Response to Planning Application

Application ref: F/14/24/RES

F/14/24/RES - Approval of reserved matters (layout, scale, appearance and landscaping) following outline consent F/4/20/OUT for the infrastructure matters including the provision of a primary spine road and associated secondary road junctions, pavement, footpaths, cycle infrastructure and bus stops; wide drainage infrastructure including foul pumping stations, foul sewer infrastructure, SUDS basins, SUDS swales, surface water infrastructure; acoustic public open space including landscape details, play areas, footpaths & associated works. This application affects a Public Right of Way, may affect the site a Listed Building and falls within CIL Zone 1 (Ford strategic site - zero rated).

Location: Land at Ford Airfield Ford

Reserved Matters Infrastructure Ryebank Park 2 of 2

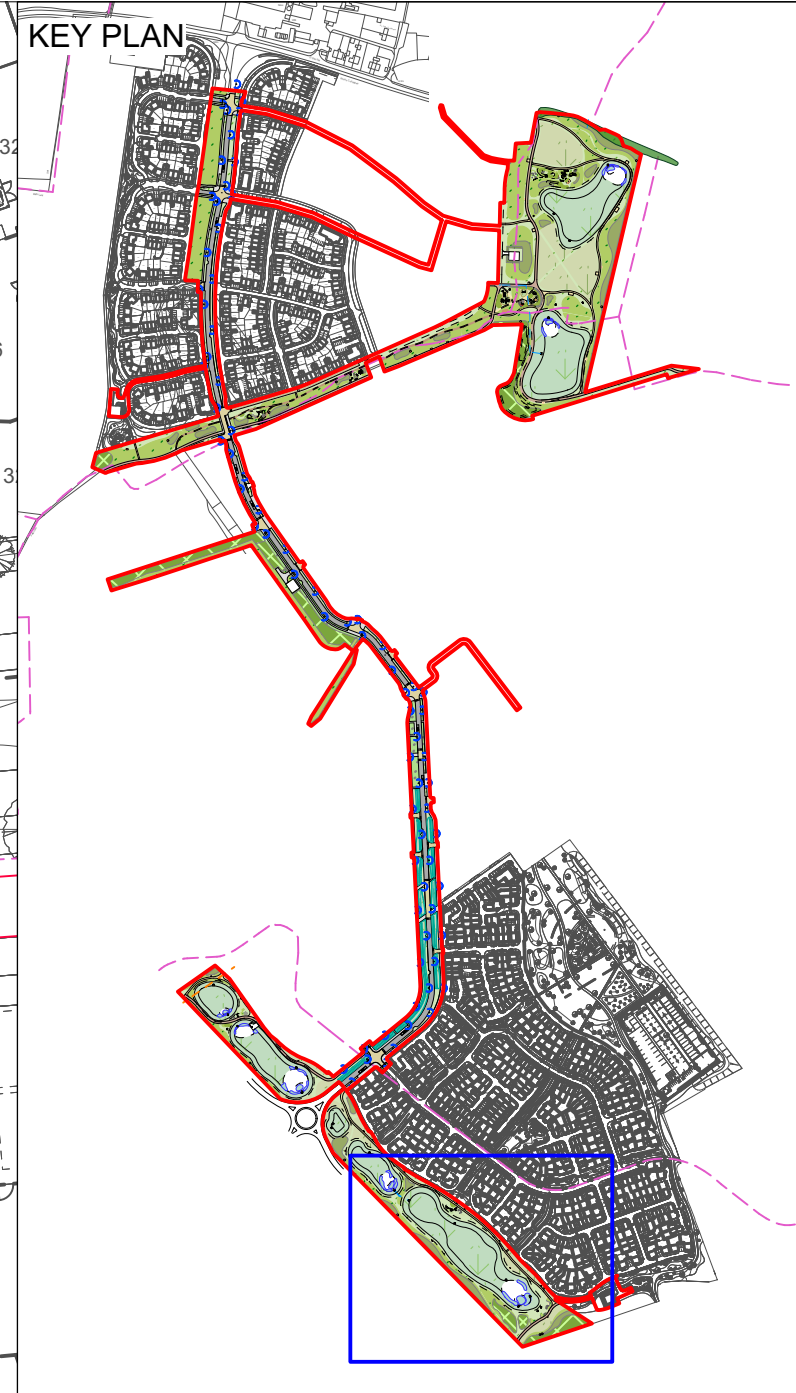
On submission of the application, two drainage basins were proposed in Landings Green POS, and a series of five basins were proposed within Ryebank Park. Concern here would be regarding their size and depth, and the lack of useable POS as a result.

Resulting amendments to the drainage features mean the omission of trees from the drainage basin areas within Landings Green and Ryebank Park, the result of which leaves no space in the area of the basin for tree planting and landscaping which is required to help integrate the basin within the landscape.

The basins within Ryebank Park have also increased resulting in a narrowing of remaining space and the basin appearing less organic in shape. Inappropriate siting of benches within this reduced area would not be supported.

Basin Section Part A
1:100

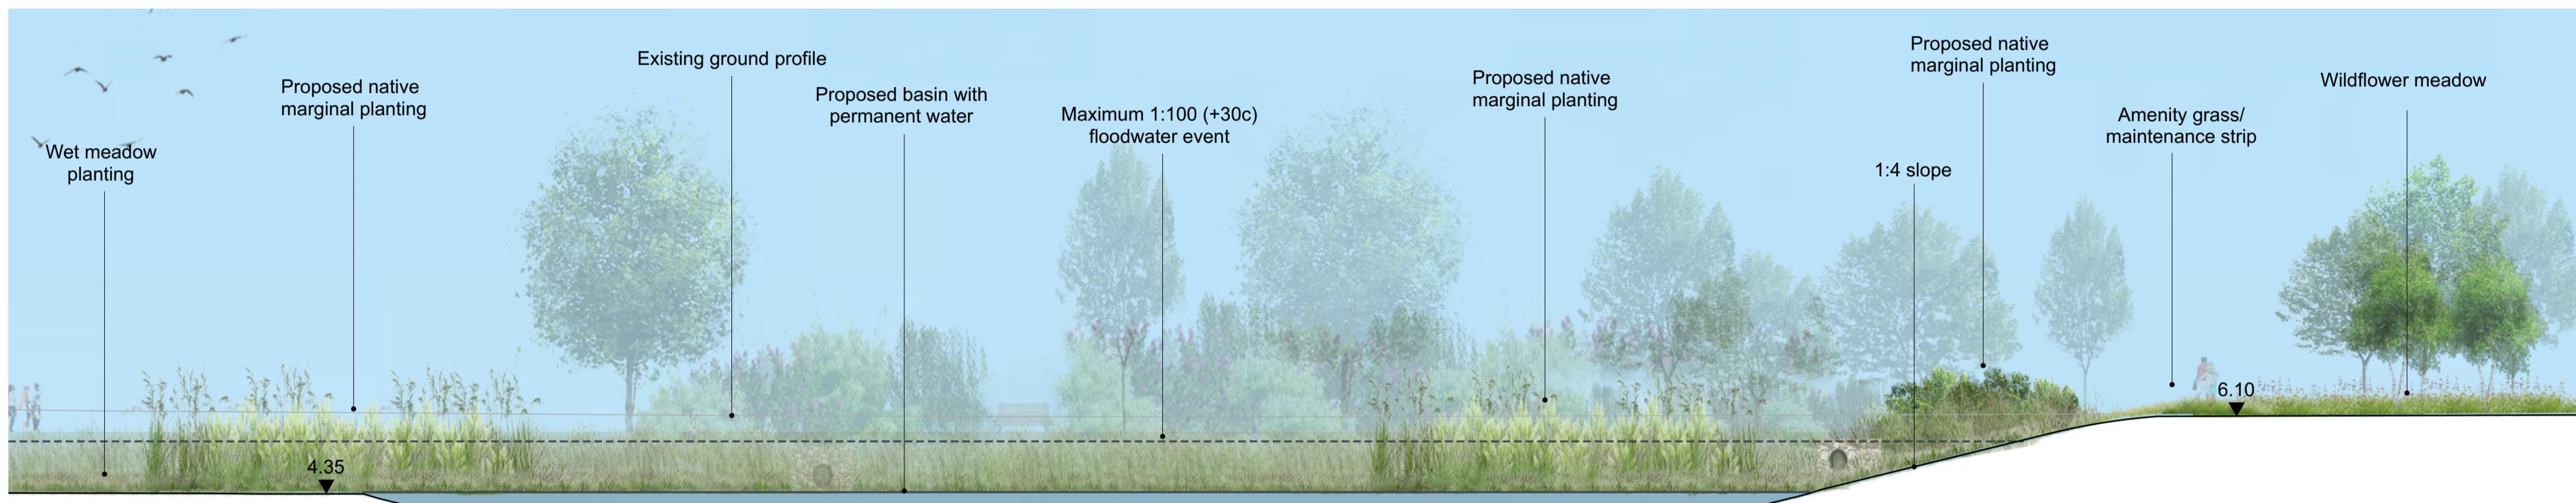
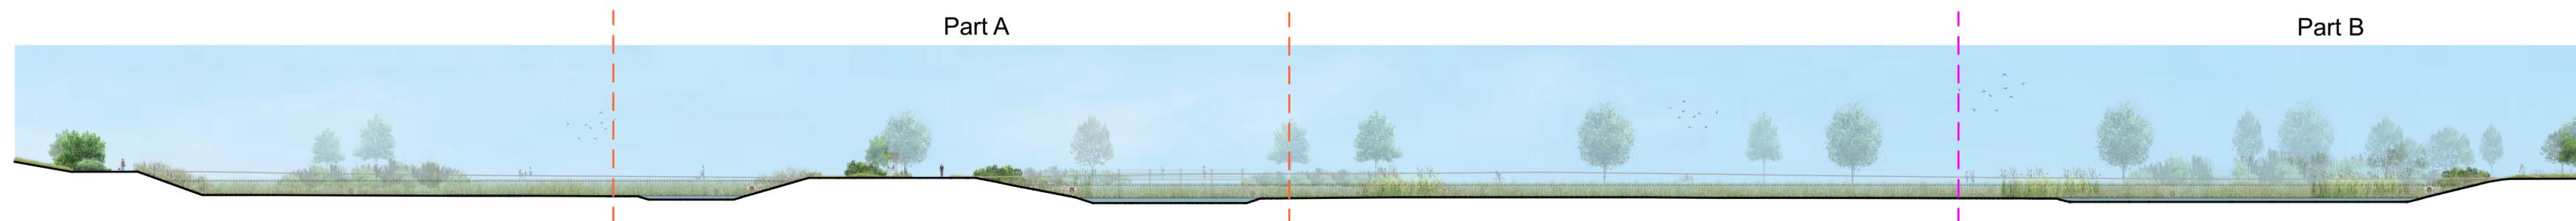
The depth of the proposed basins raise concern re aesthetics and safety, where a potential requirement for fencing may be apparent. Concern must be raised re the close proximity of play and the basins. "Fencing is generally not desirable as it may reduce the amenity benefits provided by the detention facility." where the use of fencing could erode the open parkland character required by the Design Code. However safety of this area must be a primary consideration and facilitated accordingly (ROSPA consultation would be a requirement of any SuDS in relation to play)
